From: Martyn White
Sent: 14 December 2018 12:05
To: Planning.Responses <Planning.Responses@arun.gov.uk>
Cc: Simon Davis <Simon.Davis@arun.gov.uk>
Subject: FW: BR/214/18/PL

BR/214/18/PL

The application is for a terrace of four houses which would front on to West Street. The site is part of the former tennis court to the Royal Norfolk (a listed building) and is located within the Waterloo Square and the Steyne conservation area. Further, there are a number of listed and locally listed buildings in the local area. Development in this location therefore has the potential to affect the setting of a listed building, but also the character of the conservation area.

Drg No: **RNHB.PLAN 1**

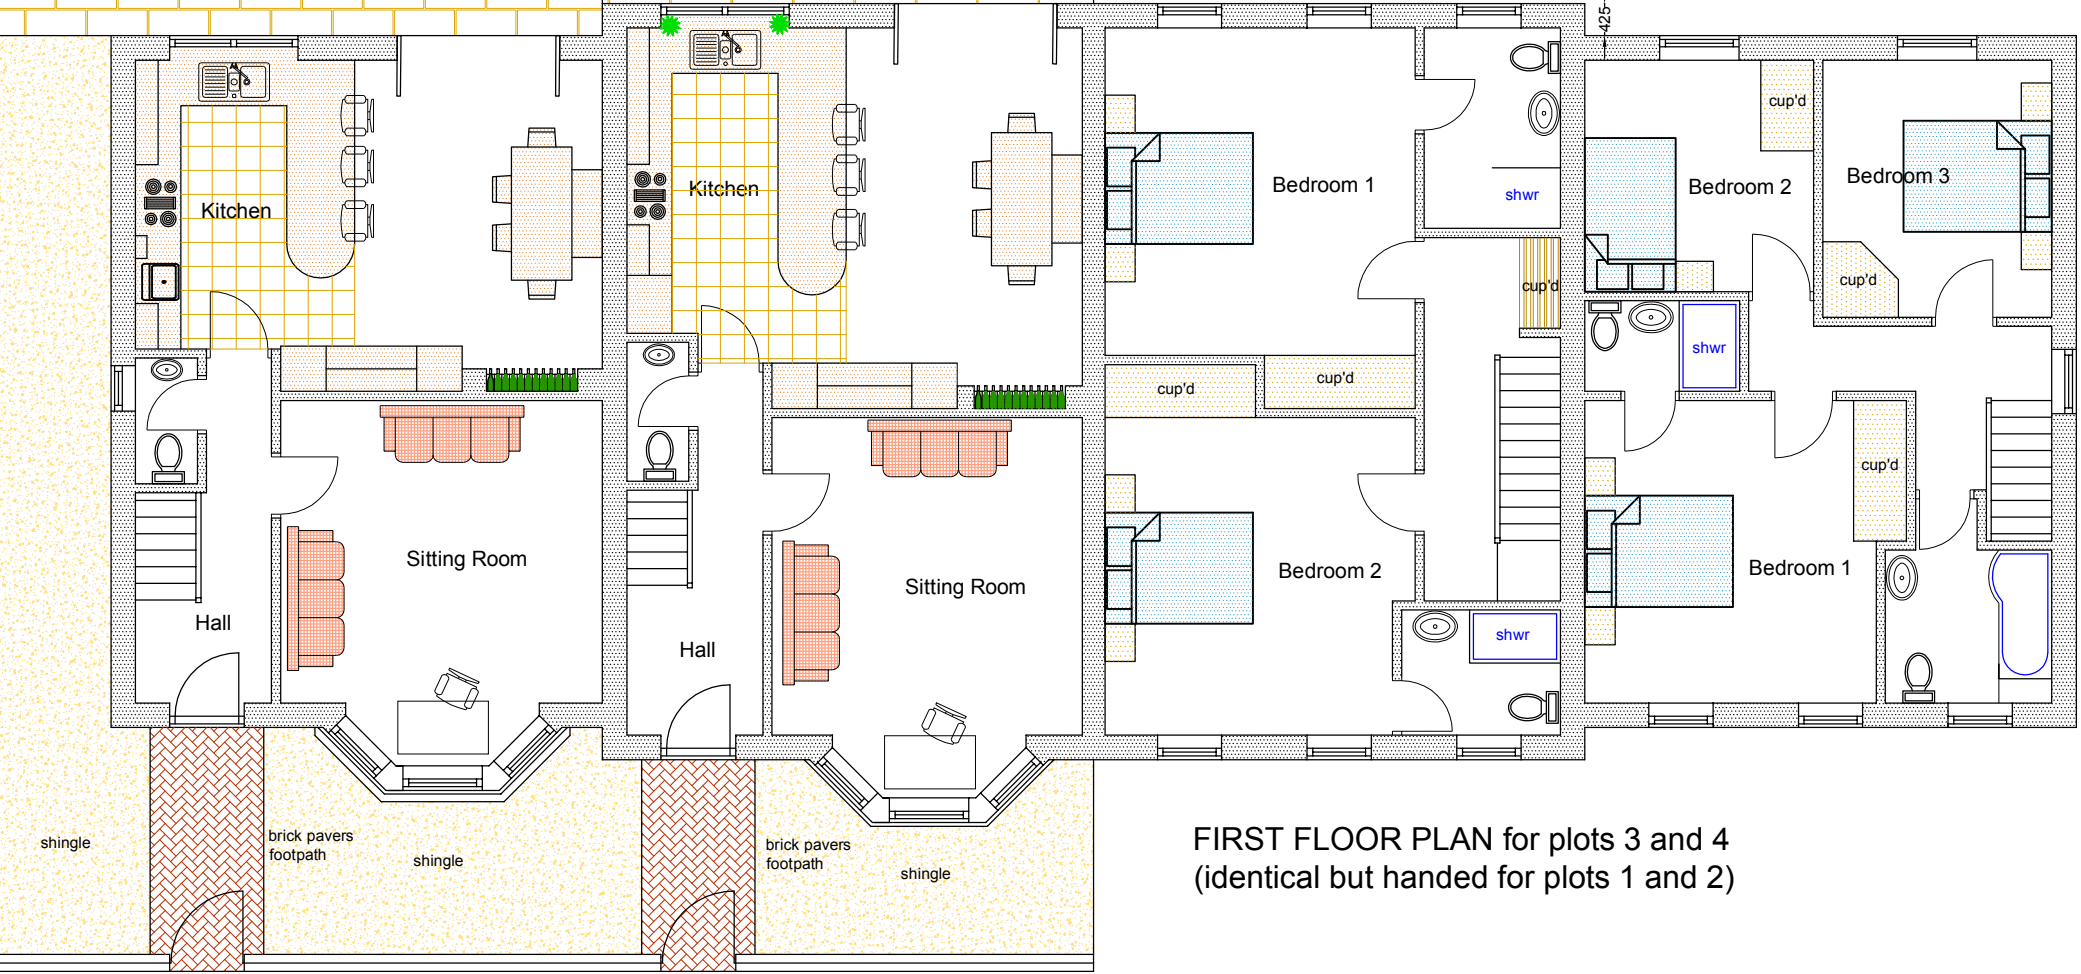
The design of the terrace is such that the middle two units would include a roof terrace. Such a feature would introduce an additional area of amenity space for use by the residents. It is considered that such a feature is not prominent in the local area, and would be in contrast to the established character. It is considered that the roof terraces would introduce further clutter in the form of garden furniture etc. which would be visually distracting, and inappropriate.

Drg No: **RNHB.PLAN 2**

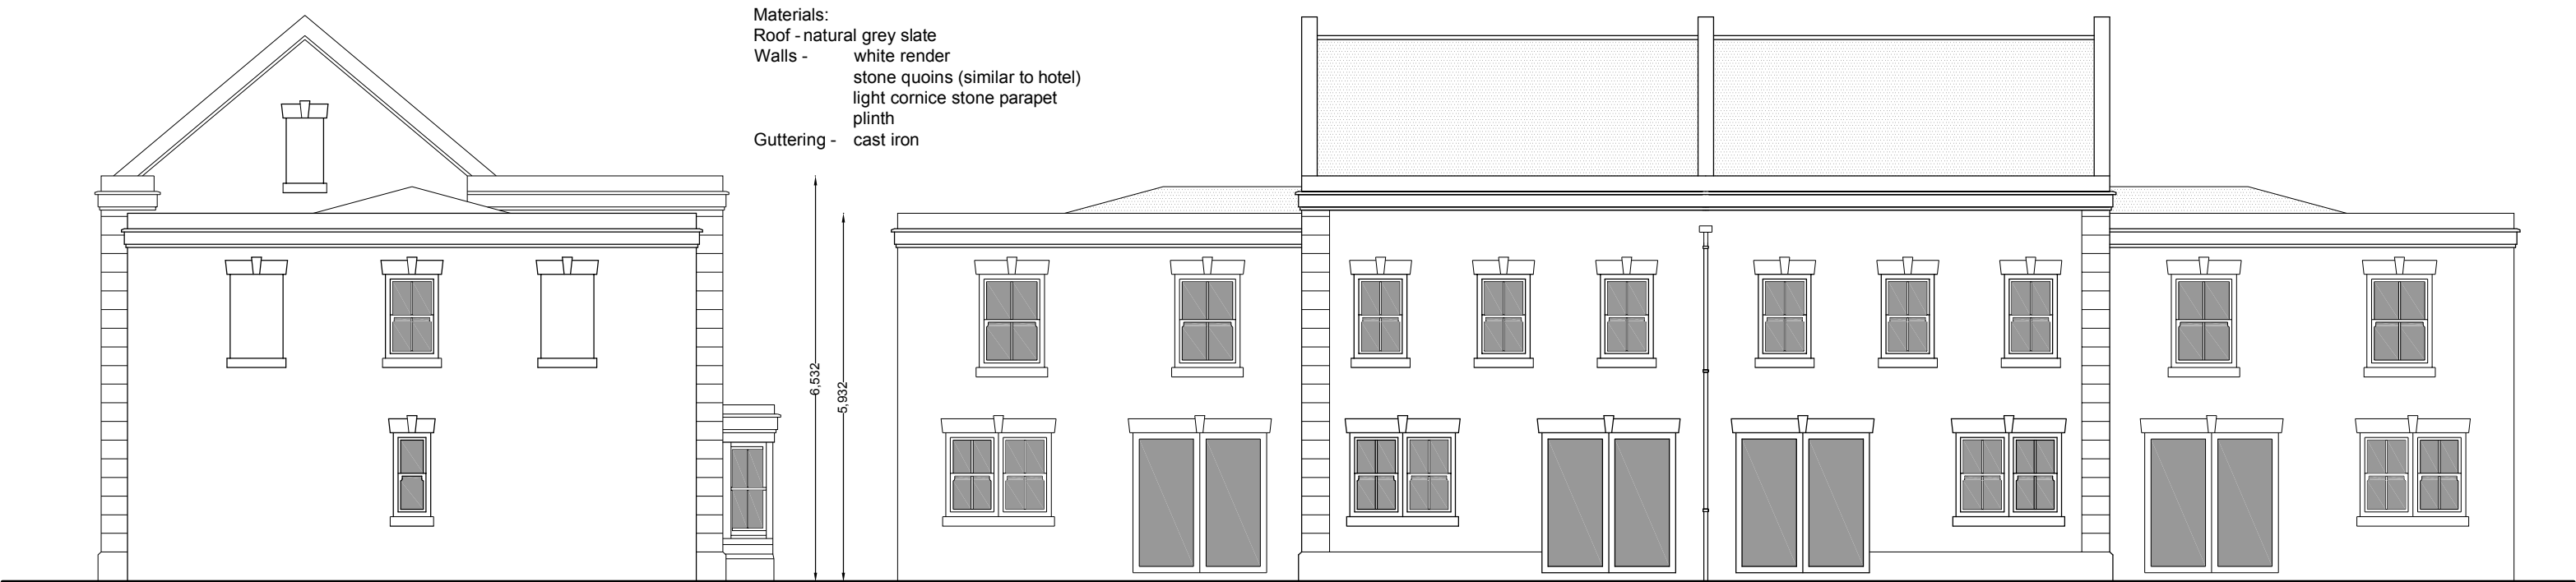
I also note from looking at the drawing which identifies the view of the front elevation from West Street, that the roof of the central two buildings would not be seen. This is in contrast to the second elevation 'view from south' which indicates that the second blue sight line would see the roof. Which is correct?
